From: Sam Dicocco
Sent: 06 July 2015 09:07
To: Planning
Subject: FW: Hatfield. 15 Church St. S6 2015/0956/FP

From: Andrew Robley
Sent: 03 July 2015 17:56
To: Sam Dicocco
Subject: Hatfield. 15 Church St. S6 2015/0956/FP

The building is a fine one and in a particularly good part of the conservation area. However, the part concerned is situated in an inner courtyard.

PROPOSED PART ROOF PLAN

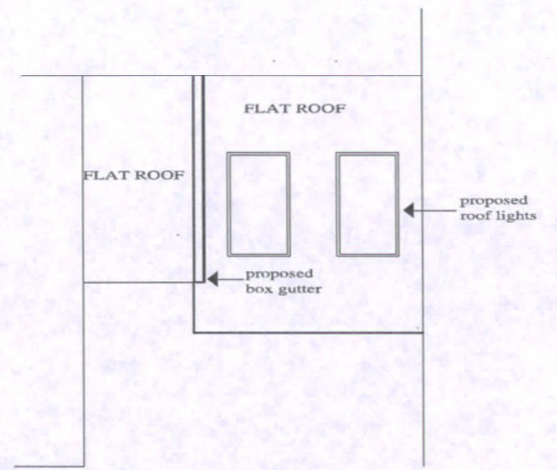
The principle of installing a solid roof is acceptable but it is shown as a flat roof, presumably finished with felt. This material is of poor appearance and I would advise that we ask them to use a metal roof, which can also be installed "flat" but it would be preferable to give it a low pitch which would then be more in keeping with the character of the building. The obvious material would be lead but this is also the most expensive and there are cheaper alternatives but of the same basic standing seam type. These would be zinc or terne coated stainless steel.

If you can persuade them to go down this route, the roof lights could then be slim metal conservation type which are not bulky and ugly like the standard flat roof lights.

Prior to the commencement of any works on site submission of precise details of the following to the DPA a) materials. Samples of, b) roof eaves, verge and abutment -1:5 section details c) roof lights- brochure details
